**Response to An Bord
Pleanála's Opinion
ABP-308945-20**

Coolagad SHD

March 2022

The report has been prepared on behalf of Cairn Homes Properties Ltd in response to Item 12(f) of the Application Form.

A VISIBILITY ENVELOPES ON APPROACH TO TRAFFIC SIGNALS
Scale: 1:500

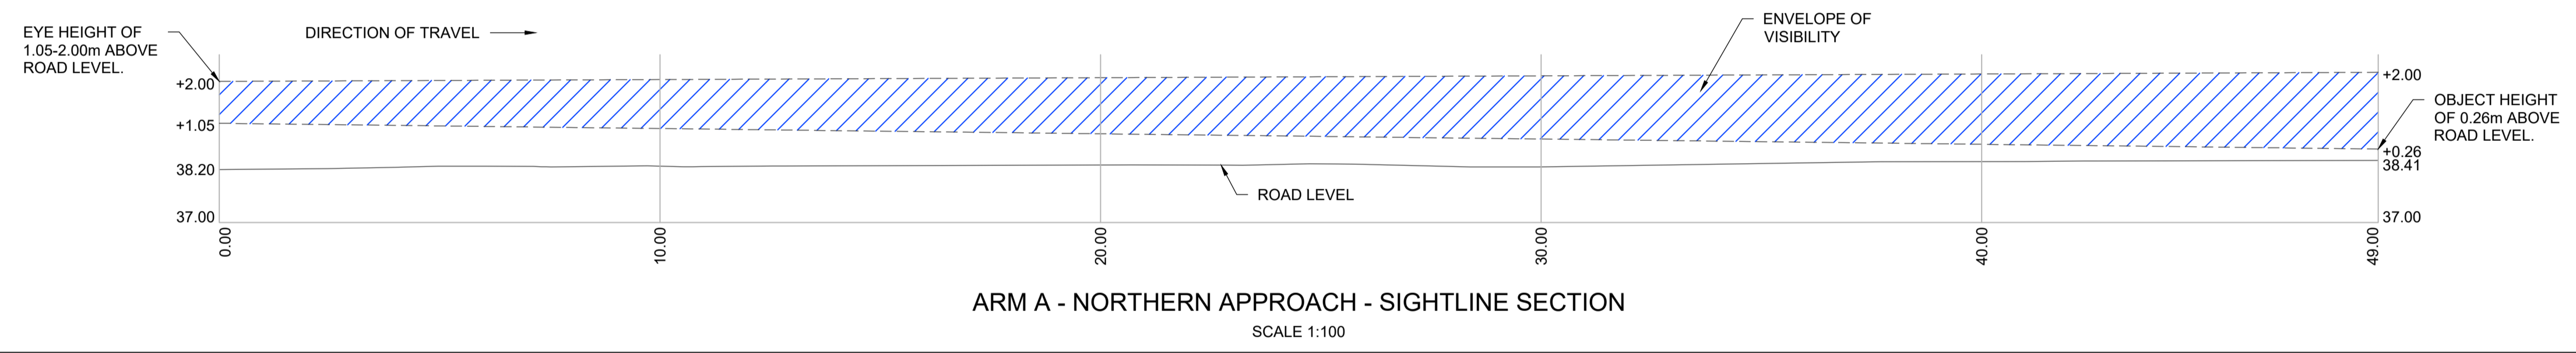
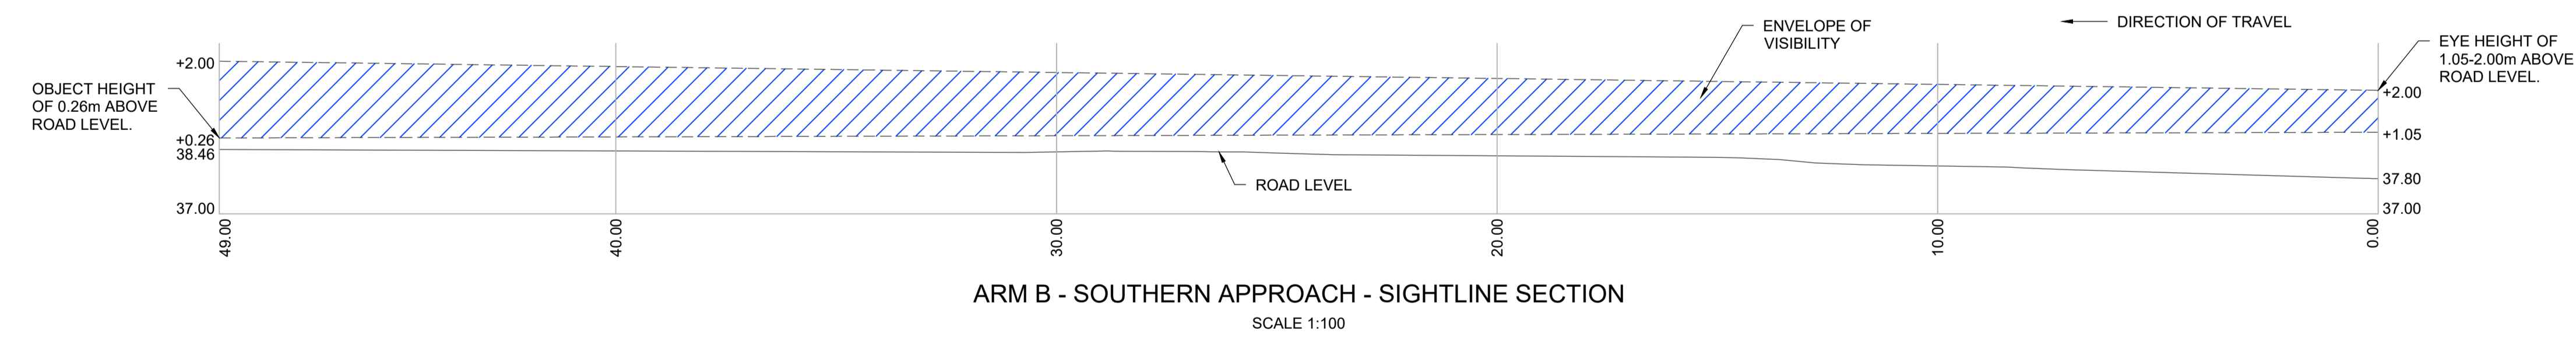
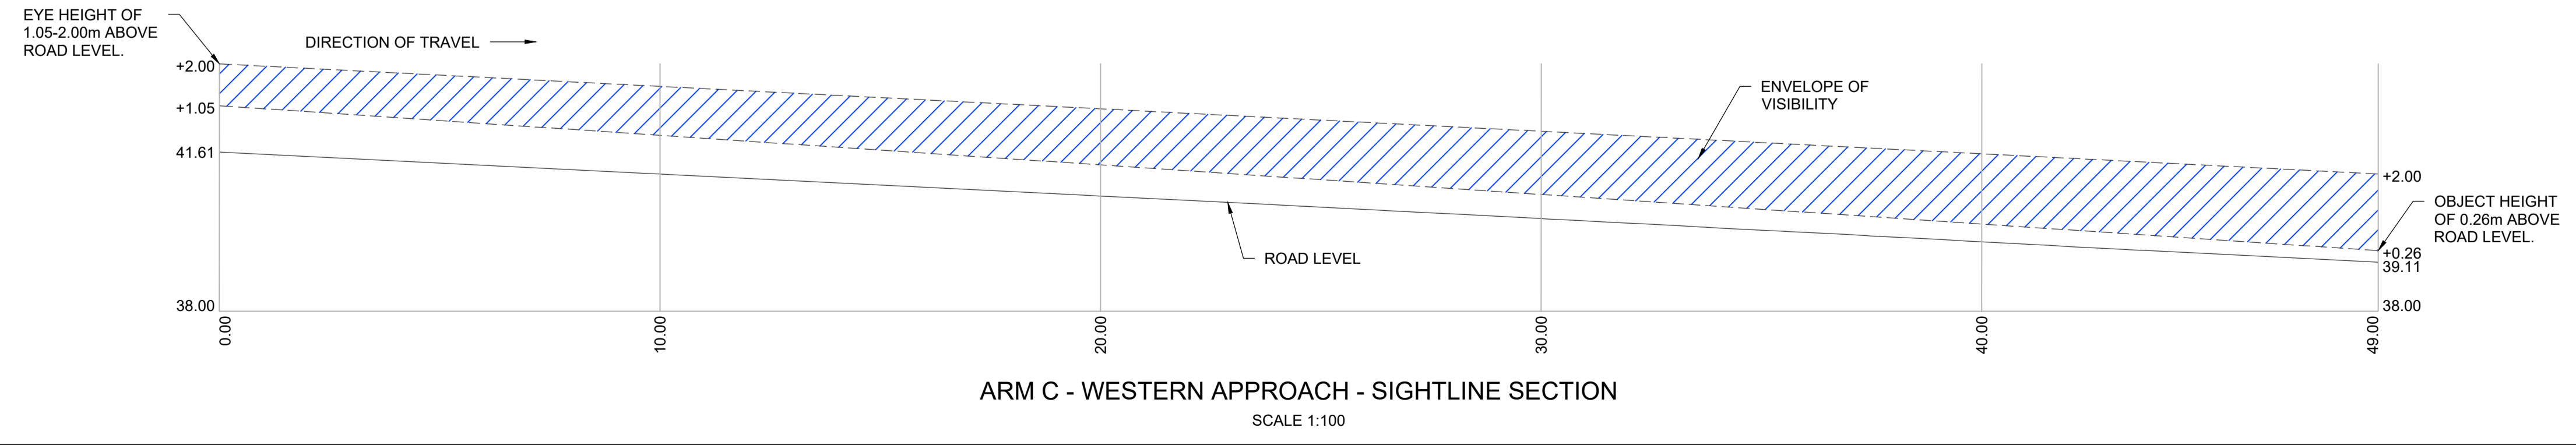
The revised documentation should include details of the proposed new access onto the R761, the capacity of the road network, available sightlines, pedestrian and cycle facilities, car parking requirements and should provide recommendations for potential improvements to the public road, if required. Further consideration of the concerns raised in the report of Wicklow County Councils Greystones Municipal District Engineer dated the 20th January 2021.

The sightline analysis undertaken for the development is shown on drawings 0101 to 0104.

SECTION 05
Scale H 1:1000, V 1:1000

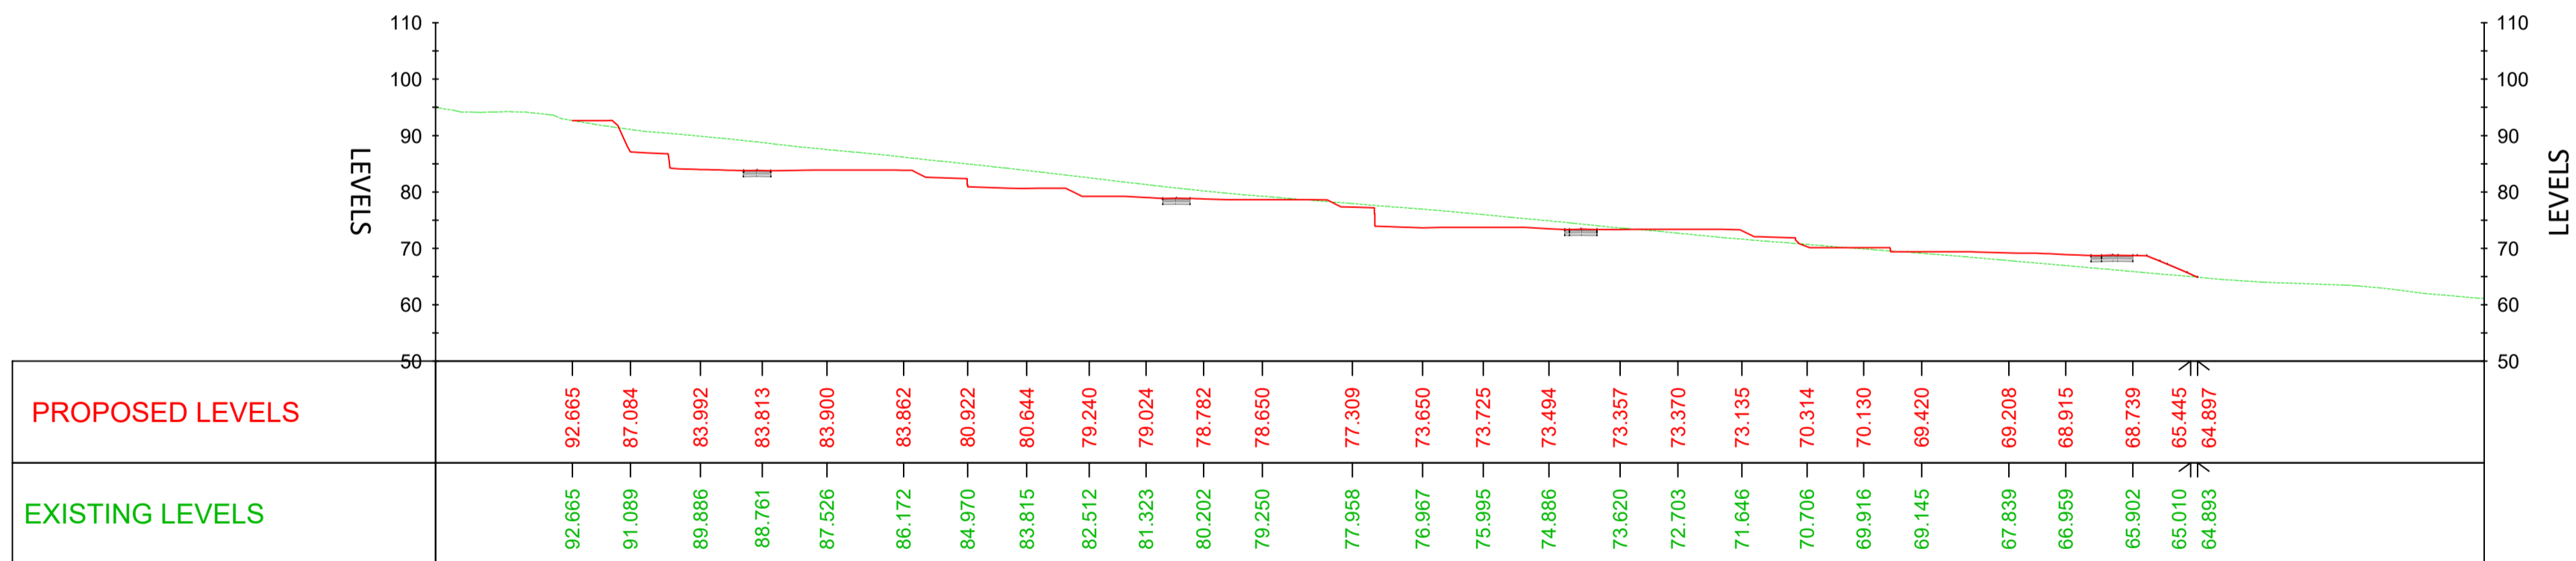
- b. the potential negative impact on residential amenities, in terms of overlooking, overshadowing or overbearing impact, due to the topography of the site and the potential requirement for retaining features.

At the outset, it is important to reiterate that the site avails of a challenging topography as noted in the Greystones-Delgany and Kilcoole LAP and in various documentation submitted as part of this application. We make particular reference to engineering drawing numbers 0610 to 6015 Cut and Fill Analysis sheets 1 to 6. The internal network essentially achieves the following:
